**Sent:** 15 February 2012 16:50  
**To:** Planning  
**Subject:** Planning application S6/2011/2593/FP - 2 De Havilland Close

**Response to Planning application from Hertfordshire County Council (T and CP GDP Order 1995)**

**Location**  
2 De Havilland Close  
Hatfield

**Proposal**  
Change of Use of dwelling house (C3) into 5 bed House in Multiple Occupation (C4) and three independent bedsits

2 DE HAVILLAND CLOSE, BLOCK PLAN
SCALE: 1:500

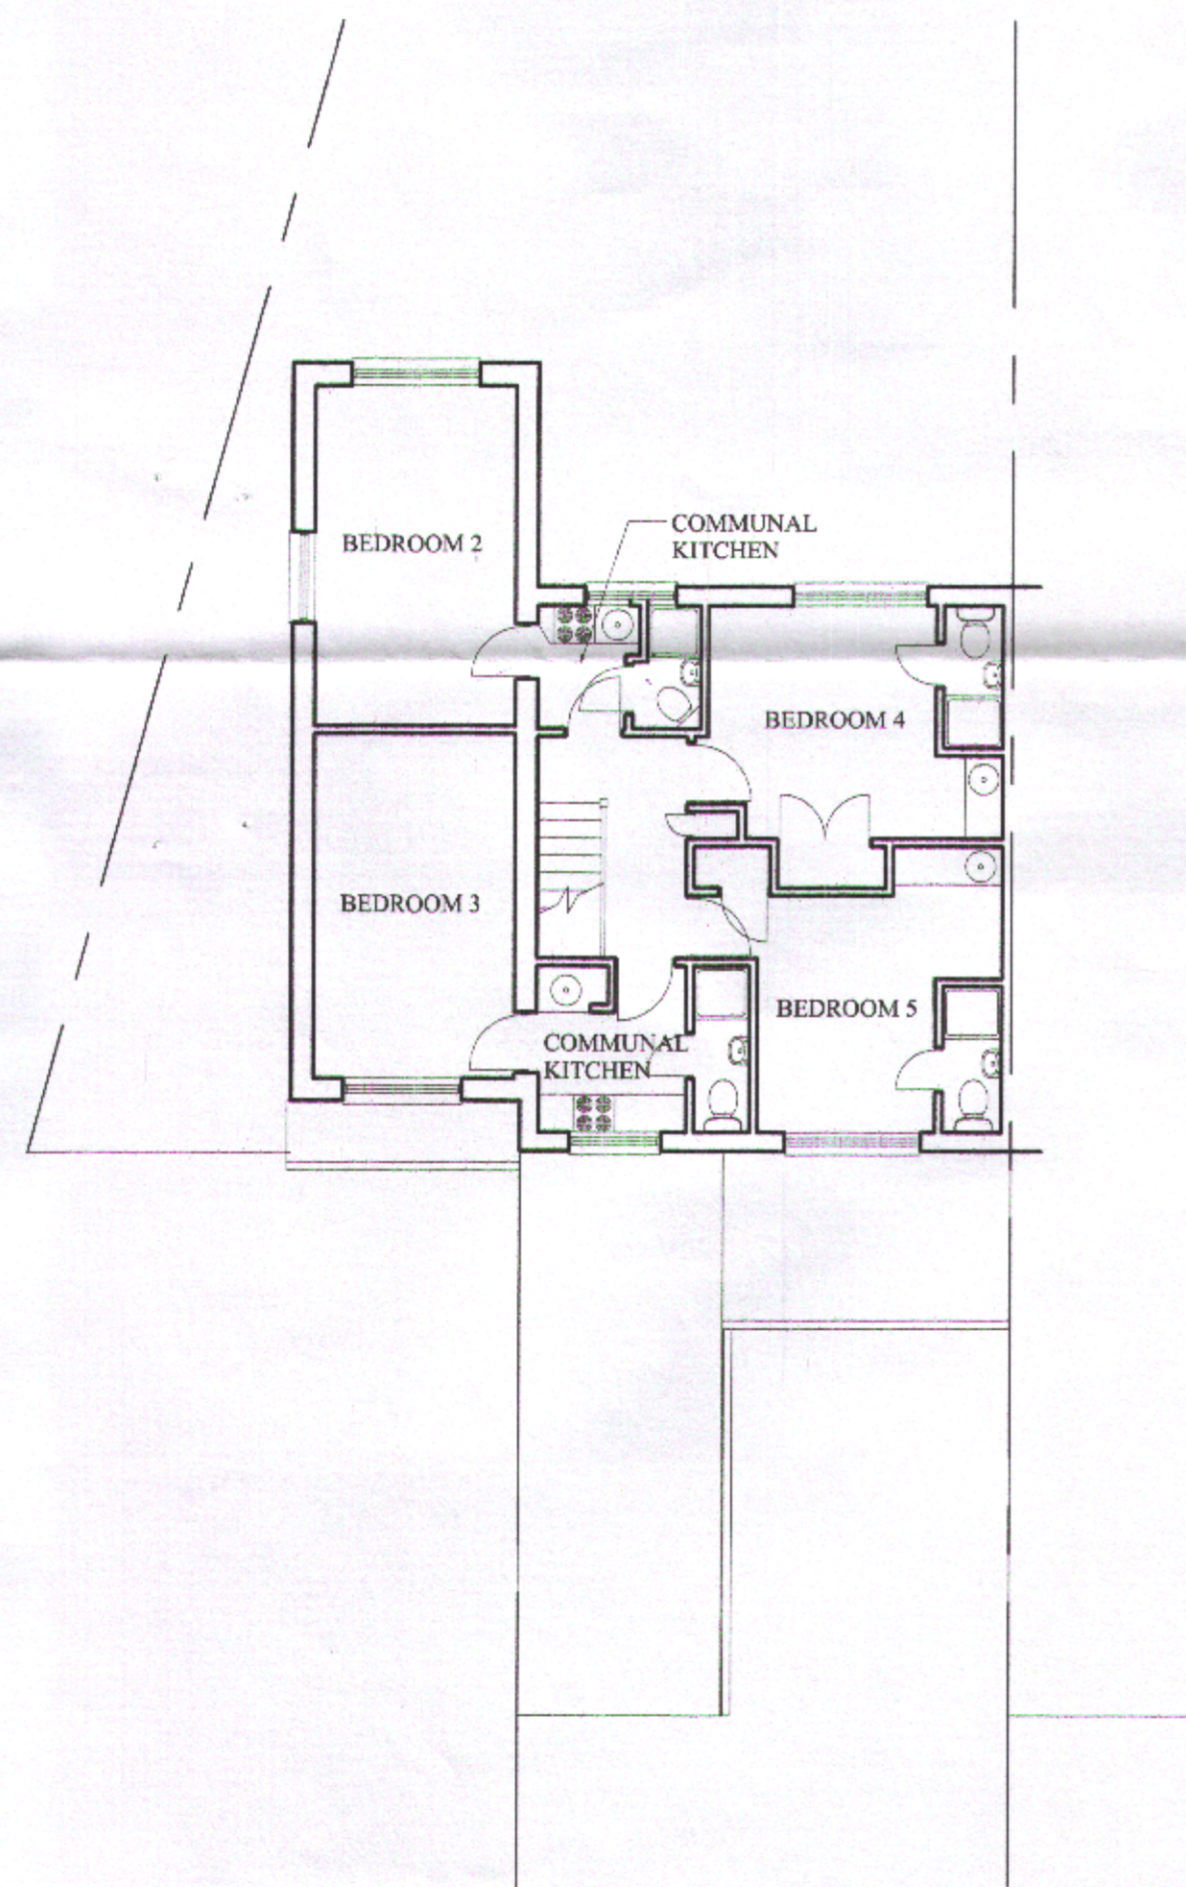
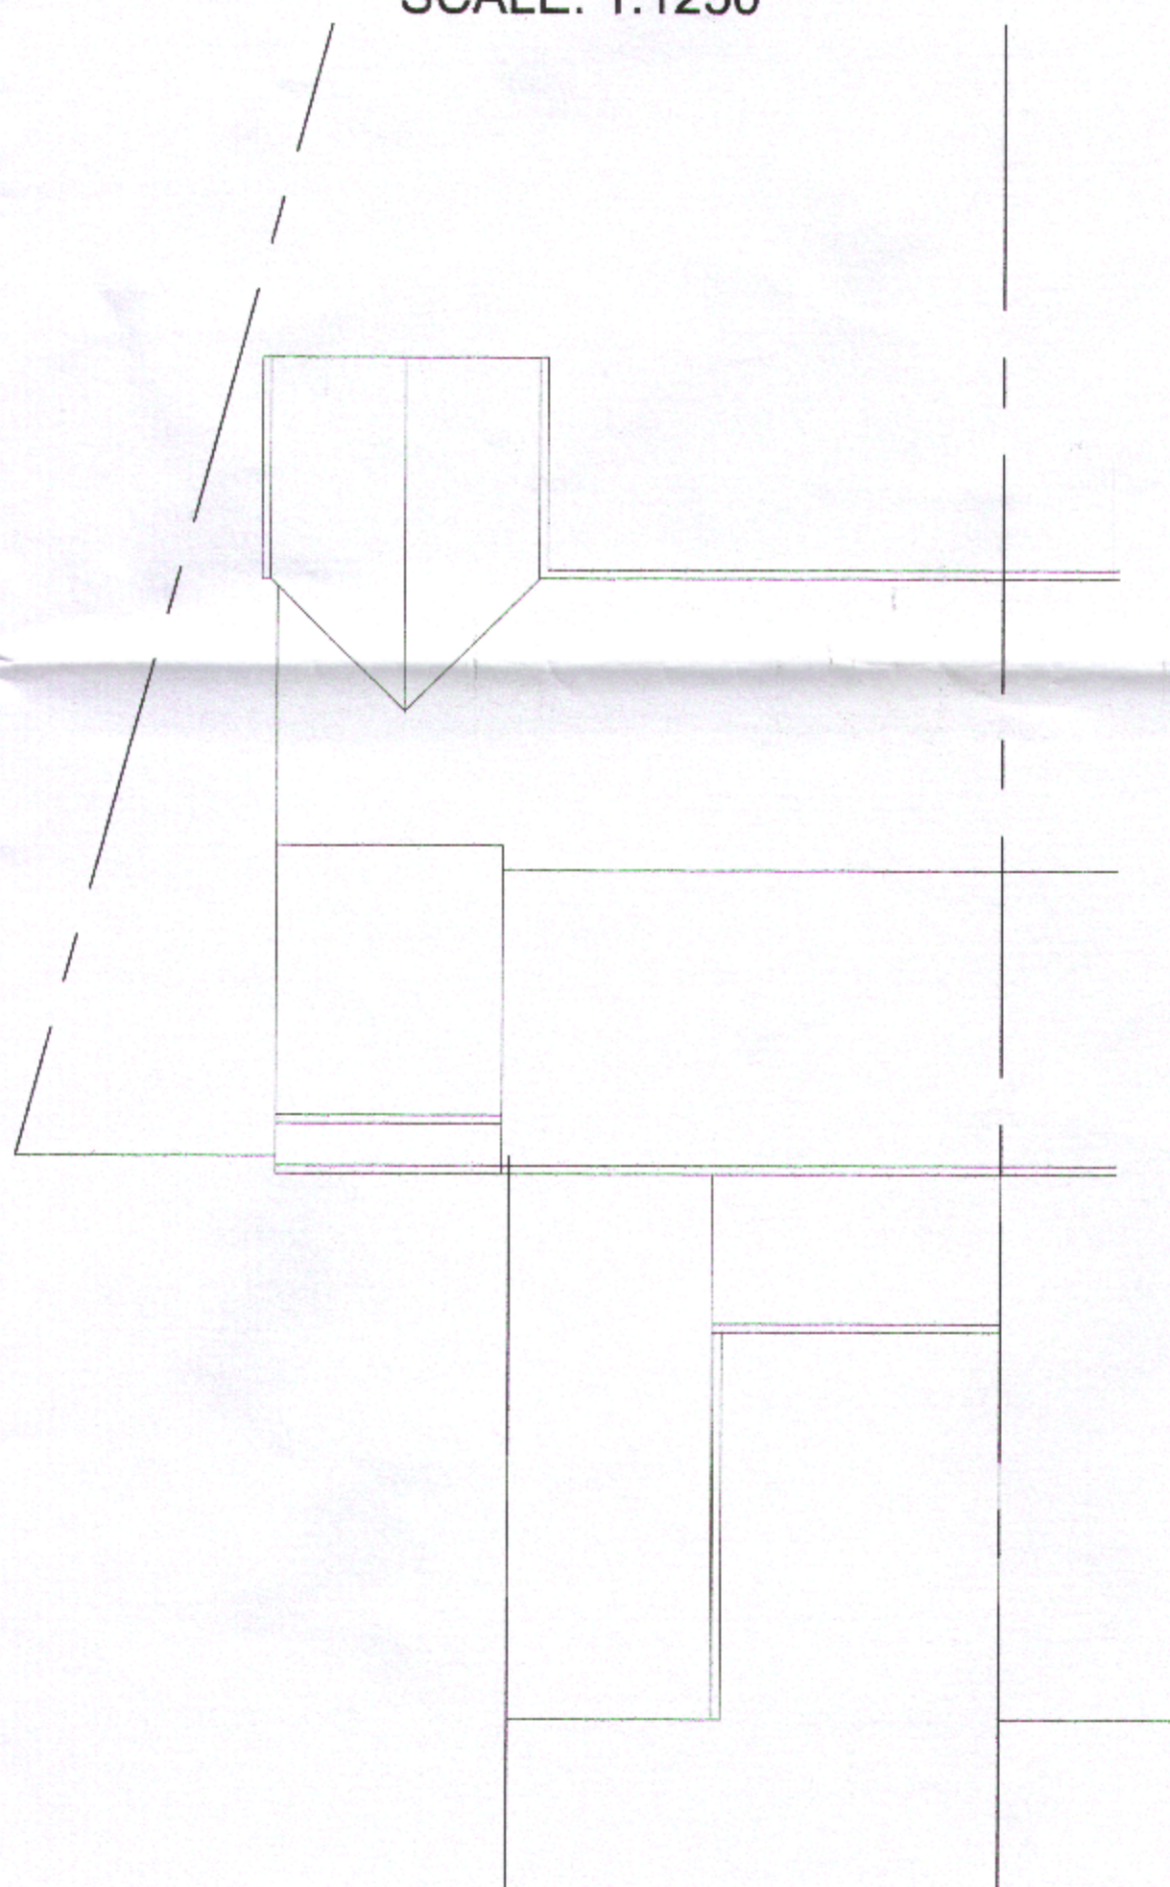
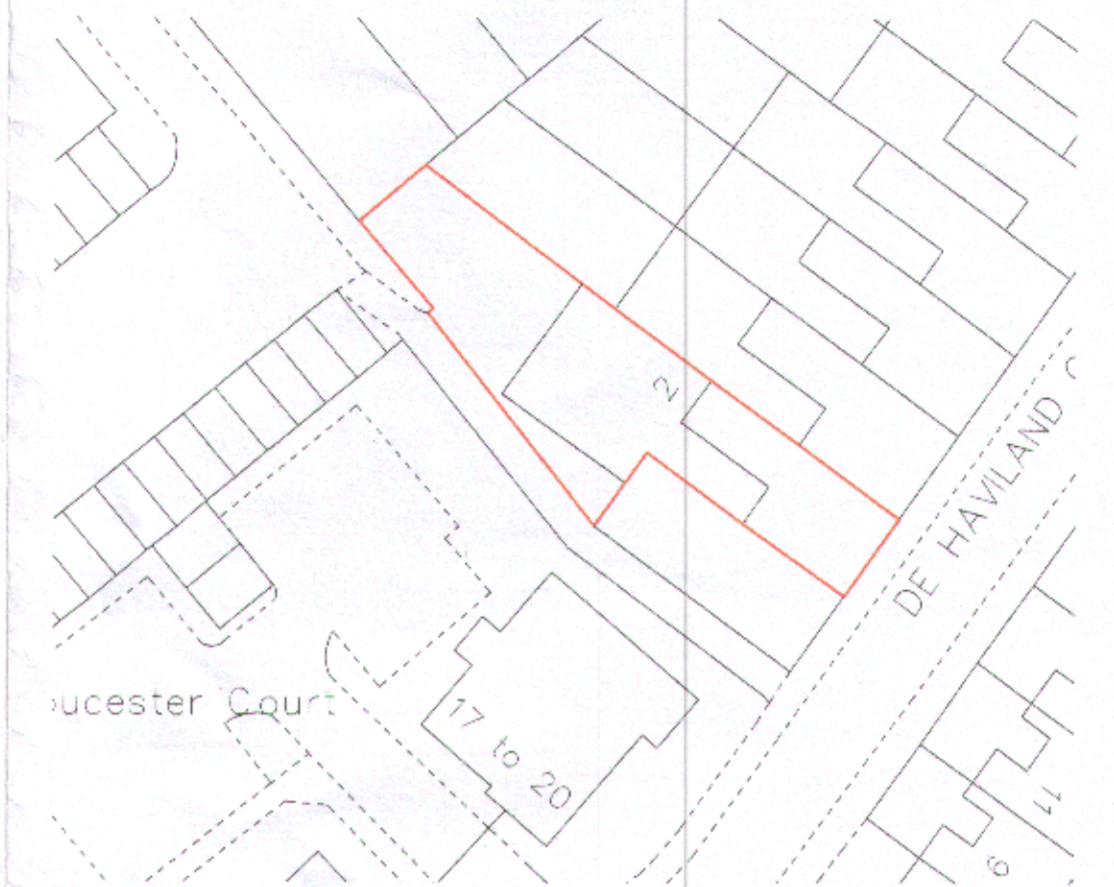
The applicant has not demonstrated that adequate pedestrian visibility can be provided from the rear parking spaces and without this information the proposal will be detrimental to pedestrian safety.

COMMENTS: This is a retrospective application is for the change of use of the existing dwelling house (C3) into 5 bed House in Multiple Occupation (C4) and three independent bedsits. It is proposed to provide 5 car parking spaces three at the front of the property accessed from the existing dropped kerb in De Havilland Close and two in the rear of the property. These will be accessed through a rear garage forecourt and the applicant would need to show that he has a right of access through this parking area and the driveway serving it. The footpath on the northern side of the driveway to the garage forecourt which continues on the southern side of the property is however part of the public highway and the applicant has not demonstrated adequate visibility from these parking spaces. A 2m x2m visibility splay should be provided on each side of the access serving these spaces to ensure adequate visibility between pedestrian and vehicles using these spaces. WHBC are the parking authority and will determine the number of parking spaces required by the proposal. Current parking restrictions which prevent on street parking between 9am and 11am Monday to Friday would prevent residents being able to park a car permanently on street.
